STERLING RANCH FILING NO.2

STREET IMPROVEMENT PLAN

APRIL 2021

SF-20-015

BYNUM DRIVE
STA 0+00.00 TO STA 9+24.77

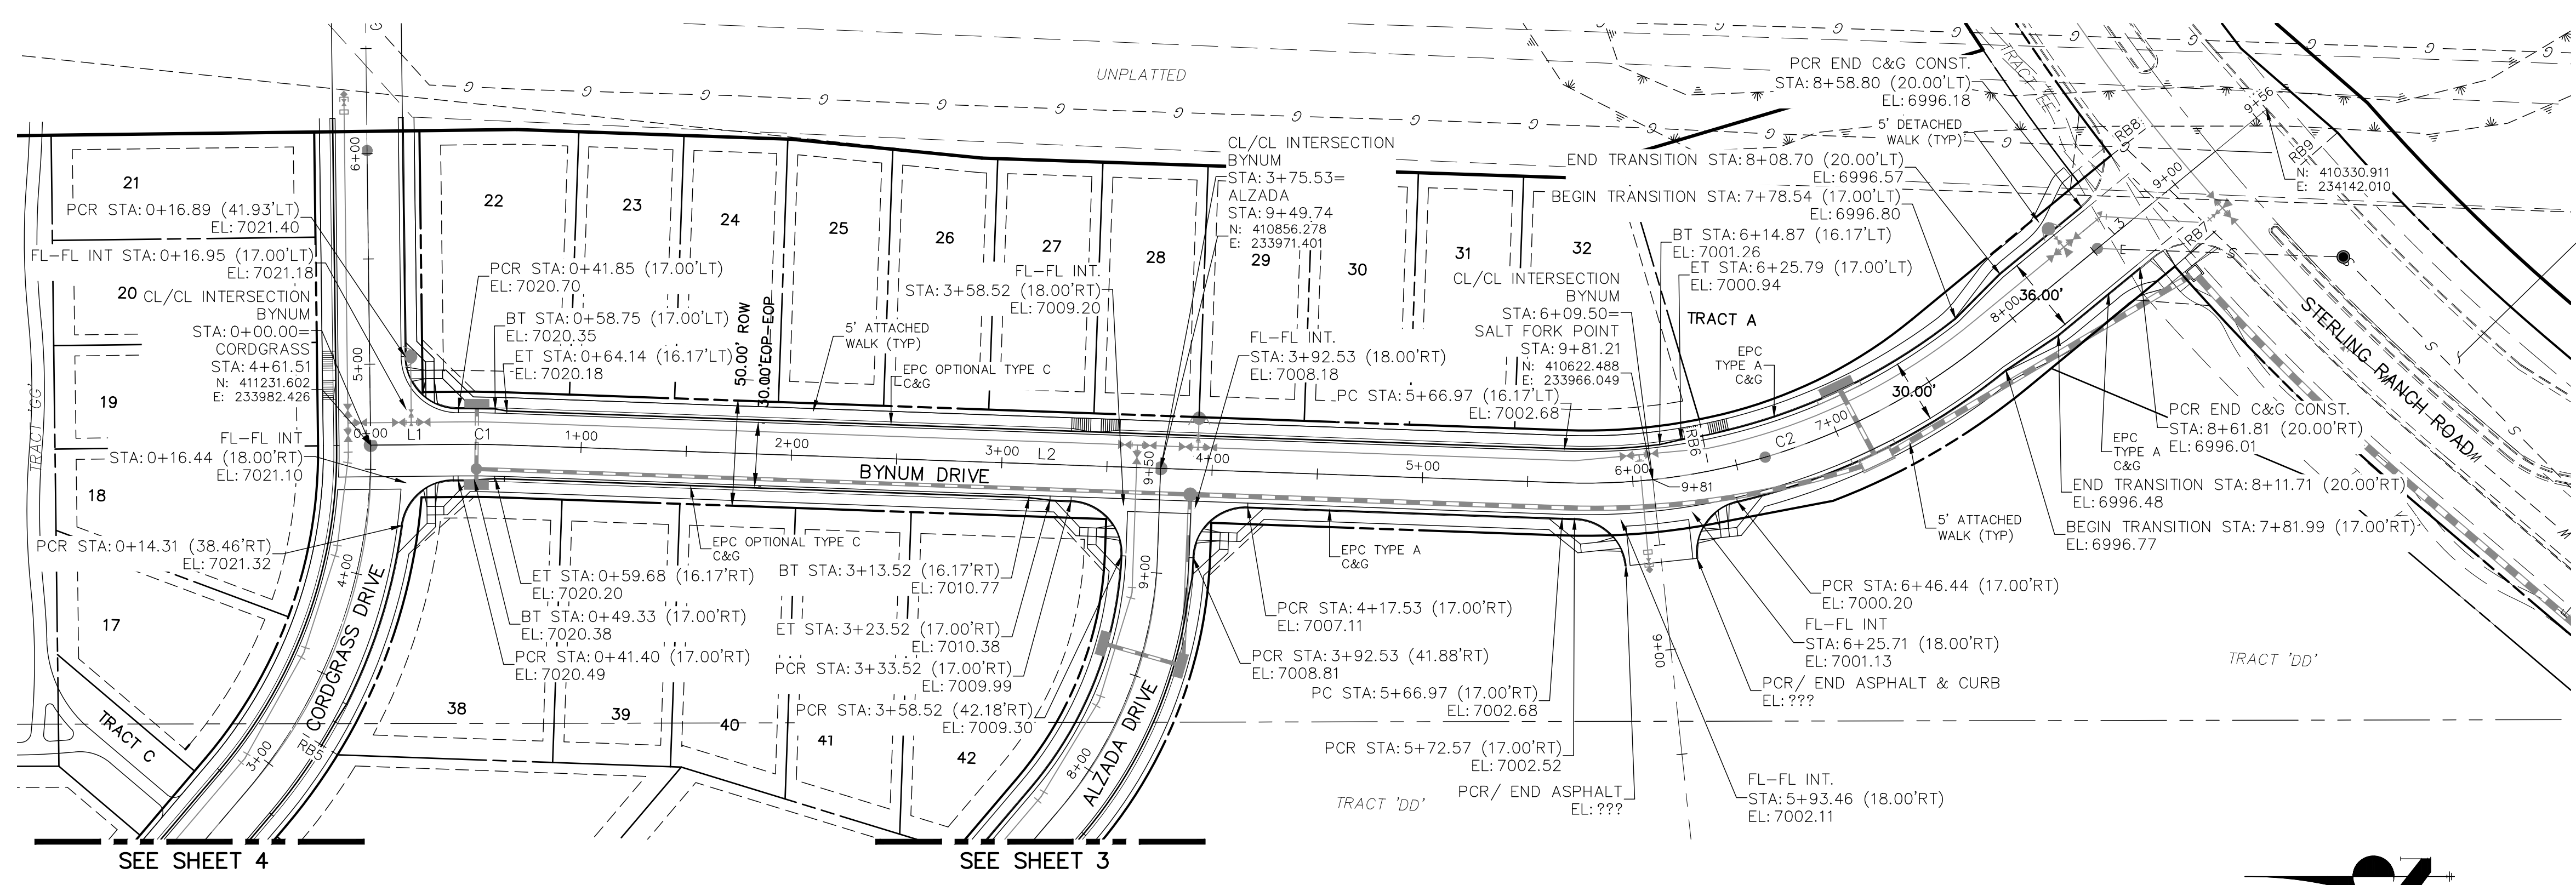
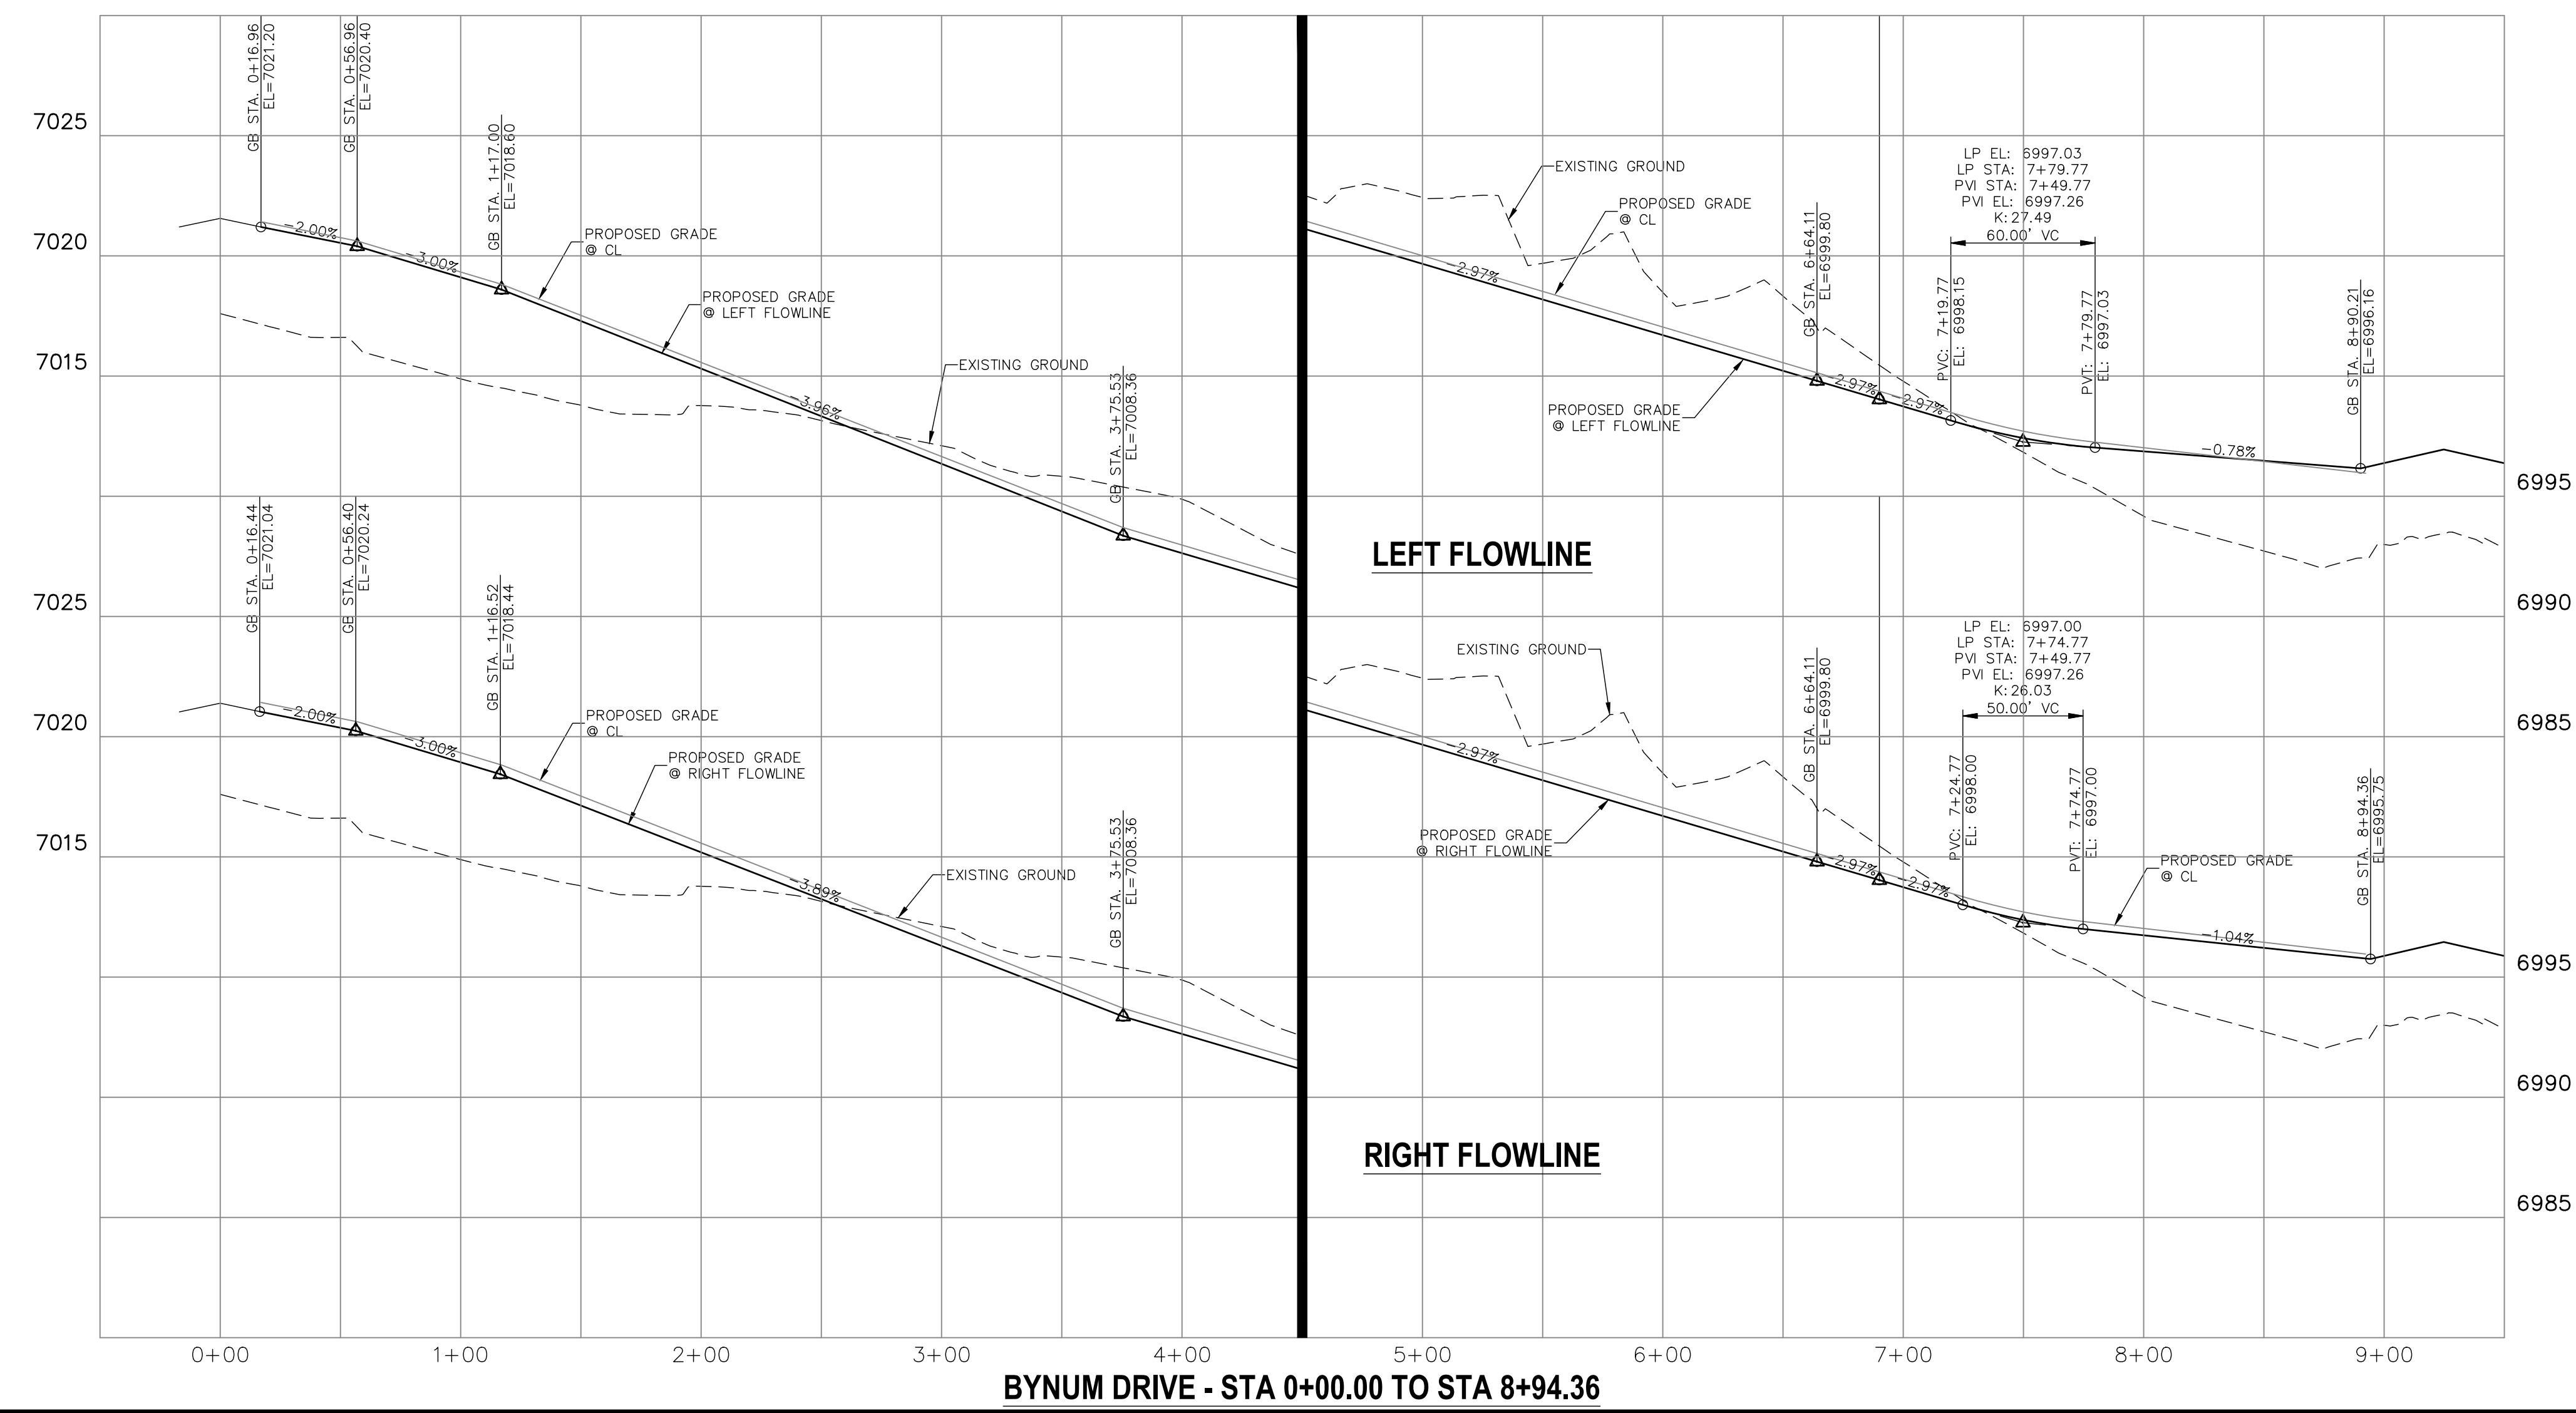
This doesn't meet ADA requirements
